Reference No: **2026/NM/91239/E**

Site Address: 12, Easby Avenue, Healey, Batley, WF17 7EW

Description: Non material amendment to previous permission
2025/91000 for erection of single storey front
extension with single and two storey side extension

DECISION – NON MATERIAL AMENDMENT APPROVED

Revisions		Planning Application for:
Date	Apr 2025	Extensions 12 Esby Avenue, Batley
		Drawing Title: Proposed Plans and Elevations
		Drawing No: S02
		Scale: As shown
		Paper Size: A0
		Rev F

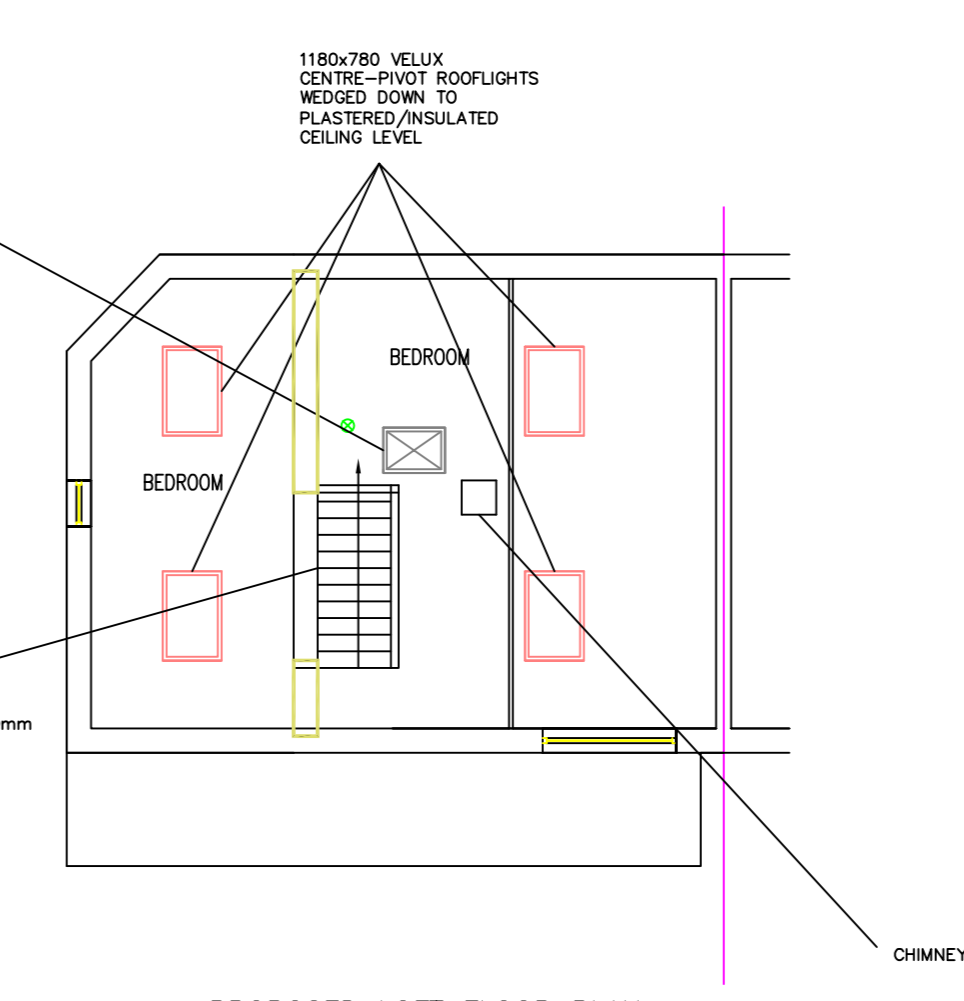
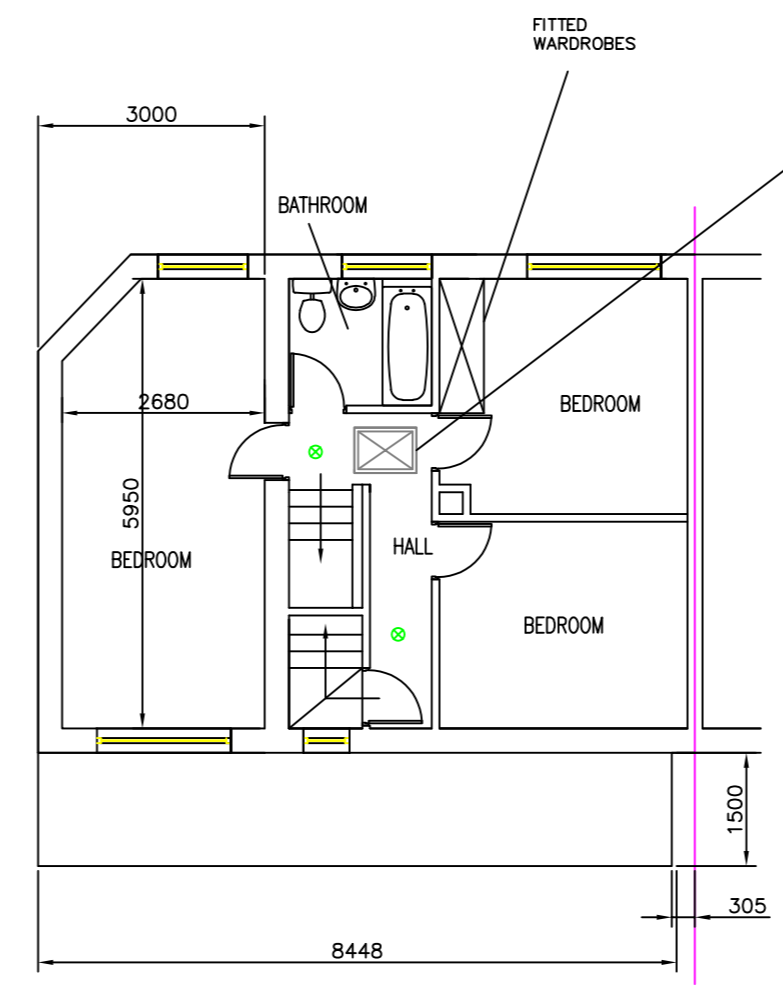
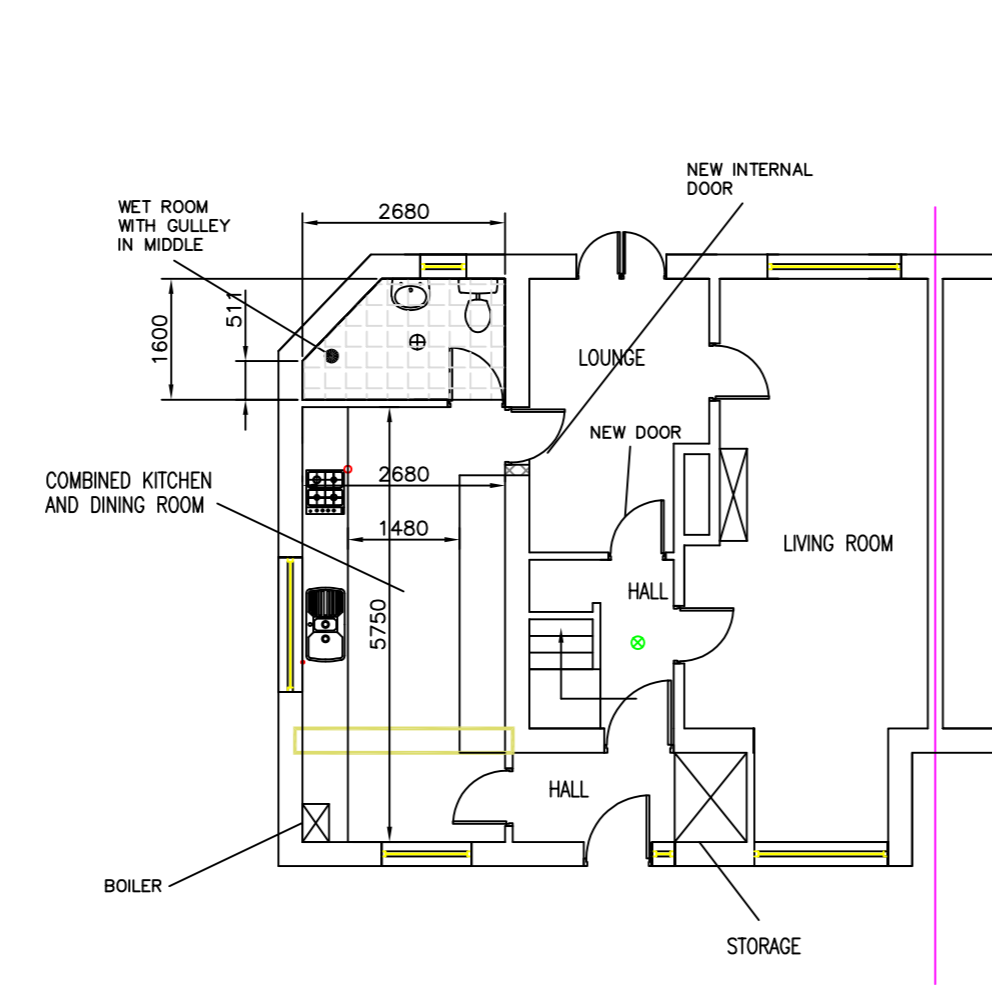
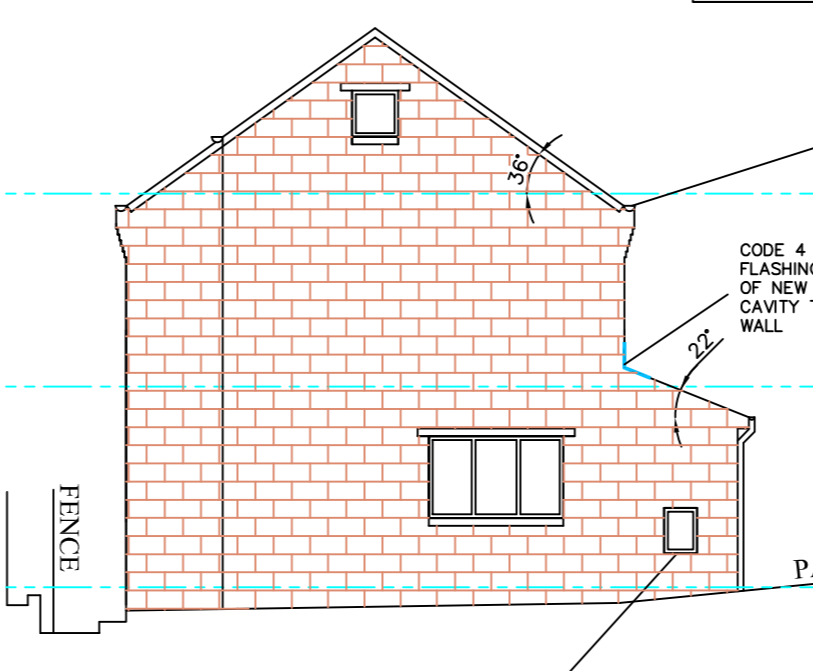
Relocation and reduction in size of the approved ground floor kitchen window on the side elevation of the two-storey side extension. The proposed window will remain on the side elevation but will be repositioned further along the wall to accommodate the revised internal kitchen layout.

The internal layout of the kitchen has been amended, necessitating the relocation and reduction in size of the approved window to better align with the revised arrangement of the space.

Officer Note: It is noted that upon the submitted drawing (ref: S02revO) a flat roofed outbuilding and flat roofed single storey rear extension are shown on the plans. No consideration is being given to these as part of this non material amendment and the amendments being considered relate solely to those detailed in the application form in relation to the development which has been so approved (single storey front extension with single and two storey side extension).

The proposed amendment relates to the relocation and reduction in size of an approved ground floor kitchen window within the side elevation of the approved two-storey side extension. The window would remain within the same elevation and is proposed solely to accommodate amendments to the internal kitchen layout. The change is minor in nature and inconsequential in scale when considered against the development as originally approved. The amendment would not result in any alteration to the footprint, scale, height, width, depth or overall form of the approved extension.

The relocation of the window within the side elevation and its reduced size would not give rise to any detrimental visual impact or harm to the living conditions of neighbouring occupiers. The interests of third parties would not be disadvantaged by the proposed change, and the amendment would not conflict with any relevant planning policies or conditions attached to the original permission.

Insofar as they relate to the relocation and alteration to the size of the ground floor kitchen window on the side elevation of the approved two storey side extension and on the basis of the window to remain on side elevation but re sited to accommodate the internal kitchen layout, the amendments shown on drawing S02O are considered appropriate to be regarded as a non-material amendment to the previous planning approval 2025/91000.
